**Deadline 2: Applicant's Response to Examining Authority's
Written Questions (ExQ1)**

**Wheelabrator Kemsley (K3 Generating Station) and Wheelabrator Kemsley North
(WKN) Waste to Energy facility Development Consent Order**

PINS Ref: EN010083

**Document 10.4
March 2020 - Deadline 2**

Status	Drawn By	PM/Checked By
DEADLINE 2 VERSION	CR	TS
Job Ref		Date Created
OXF9812		MARCH 2020
Document Reference		Document Number
9812-0031-10		5.6

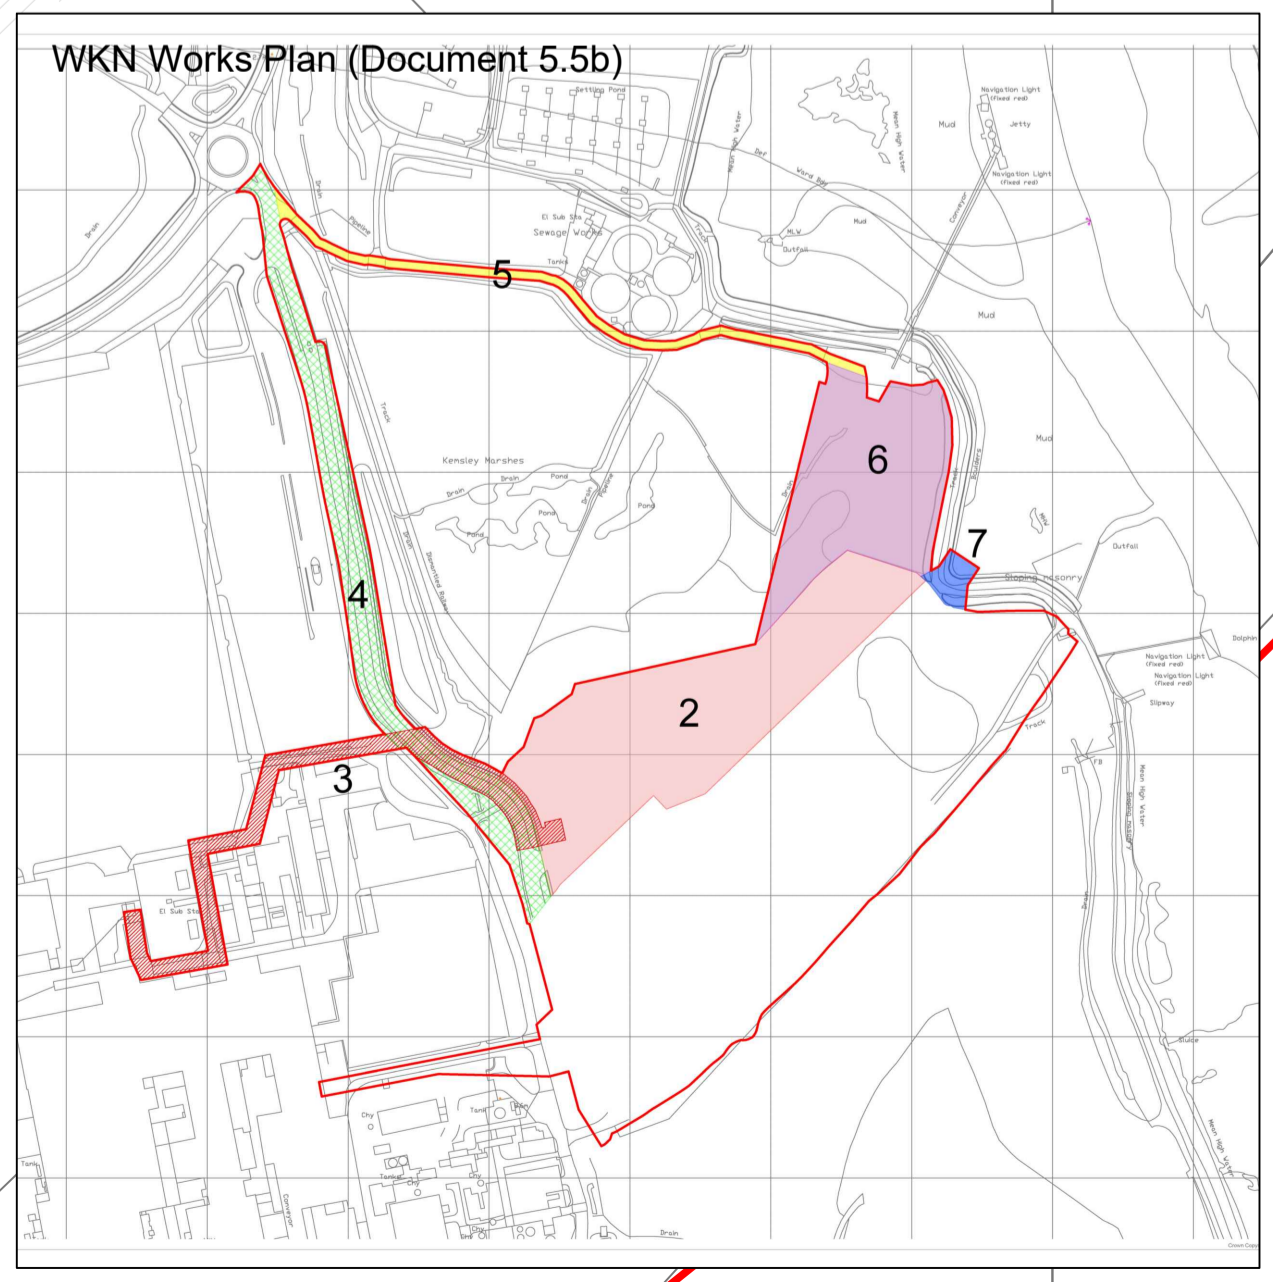
<p>The majority of the external construction of K3 has been completed. First waste fire as part of the hot commissioning of the facility commenced on the 12th March 2020 and full operation of the facility is currently scheduled to commence in June 2020.</p>	1	- 63,904.68	1A	- 5,433.40	1B	- 3,401.27	1C	- 16,866.31	1D	- 24,271.49	1E	- 911.28	2	- 24,271.49	3	- 6,971.23	4	- 12,784.67	5	- 3,018.71	6	- 14,511.48	7	- 911.28
1	- 63,904.68																									
1A	- 5,433.40																									
1B	- 3,401.27																									
1C	- 16,866.31																									
1D	- 24,271.49																									
1E	- 911.28																									
2	- 24,271.49																									
3	- 6,971.23																									
4	- 12,784.67																									
5	- 3,018.71																									
6	- 14,511.48																									
7	- 911.28																									
Q1.2.2.	The Applicant	<p>The Work Nos shown on the WKN Parameter Plan contained in Figure 2.9 of ES Chapter 2 are not consistent with the Work Nos shown in dDCO Schedule 1, replicated in R14 Table 1. In addition, dDCO R14(4) defines the WKN Parameter Plan as that certified under Article 16, although it is not one of the plans listed therein.</p> <p>Please explain the discrepancies and provide corrected plans as necessary.</p> <p>This is noted; an amended parameter plan both as Figure 2.9 of the ES and Document 5.6 - 9812-0031-10- WKN Parameter Plan have been provided at Deadline 2 consistent with the dDCO and ES Chapter 2. The WKN Parameter Plan has also been added as a certified document in Article 16 of the DCO.</p>
